03rd November 2020

Y/71/20/RES: Approval of reserved matters following outline consent Y/88/18/OUT for the erection of 38 No. dwellings, Public Open Space, a play area & drainage features. This application affects Public Rights of Way.

Land North of Yapton Church of England Primary School, North End Road, Yapton

Detailed Planting Schedule

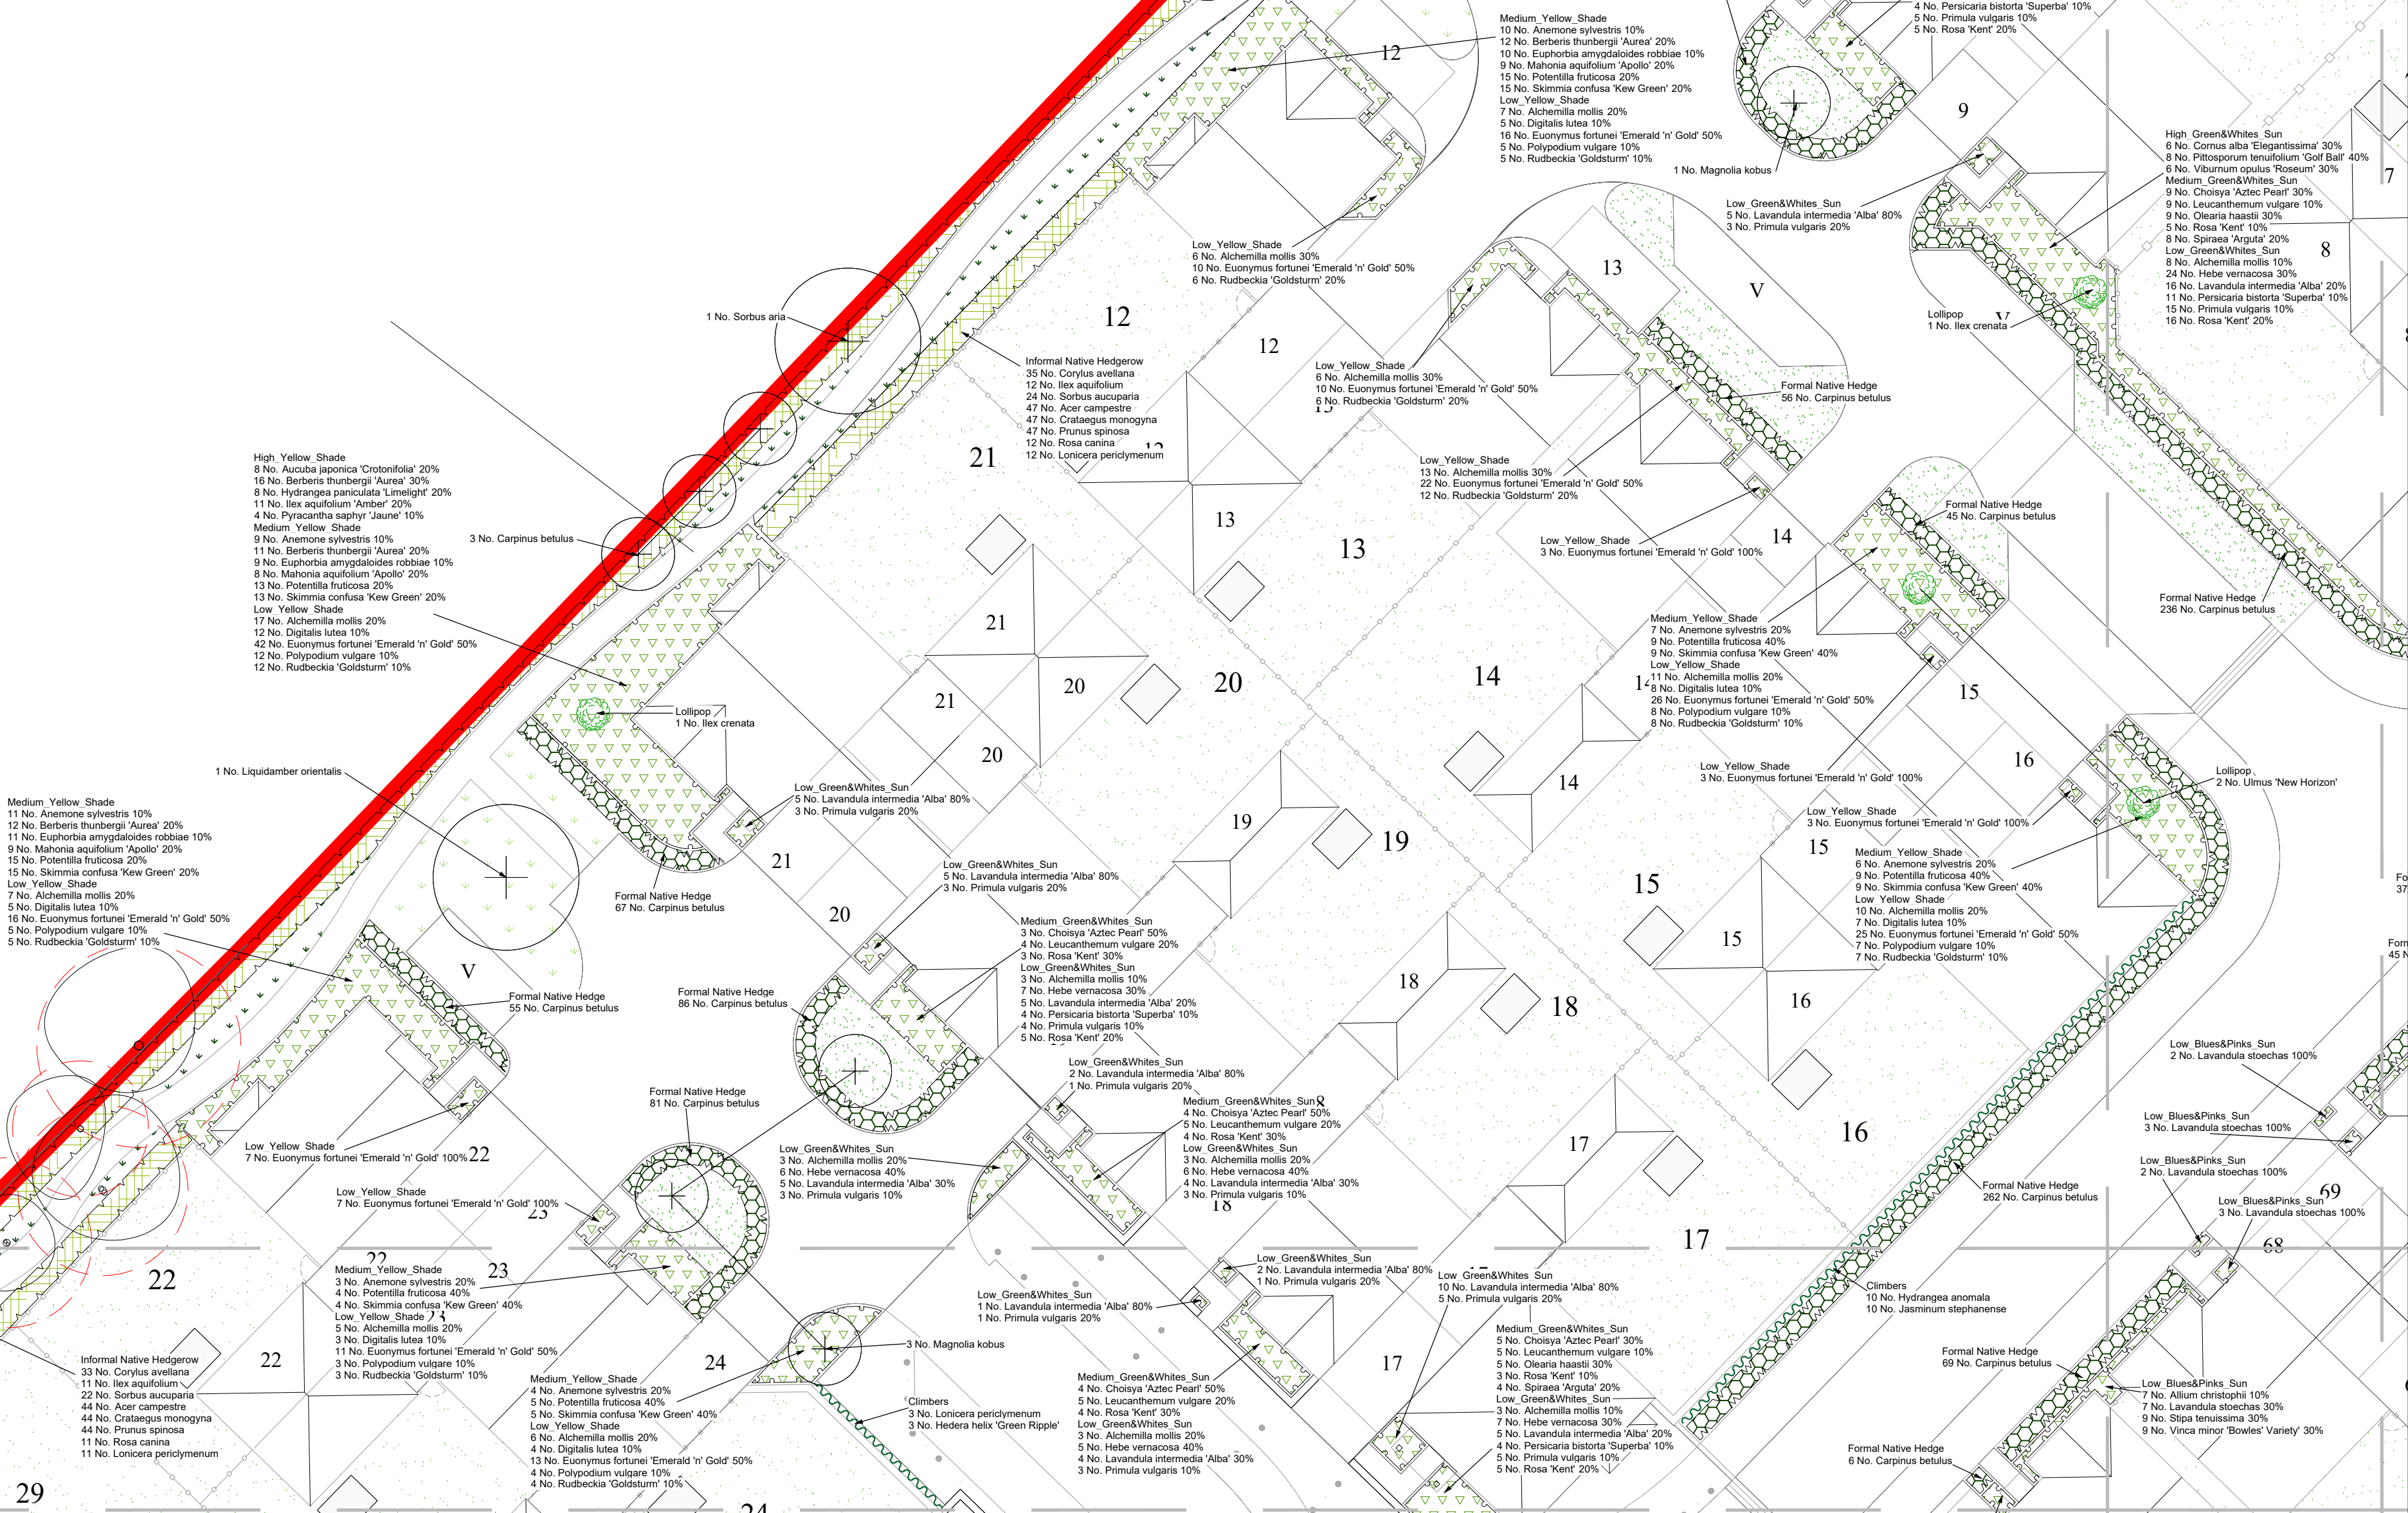
1. Amendments to detailed planting proposals to enable compliance with NHBC's Standards regards the use of low water demand species in areas with shrinkable soils. Where necessary certain species identified as being of high-water demand have been removed and replaced with low-water demand alternatives. Requirements are set out at; <https://nhbc-standards.co.uk/4-foundations/4-2-building-near-trees/4-2-4-the-effects-of-trees-on-shrinkable-soils/>.
2. The addition of gallows bracket detailing and central timber support to car parking spaces beneath dwellings;
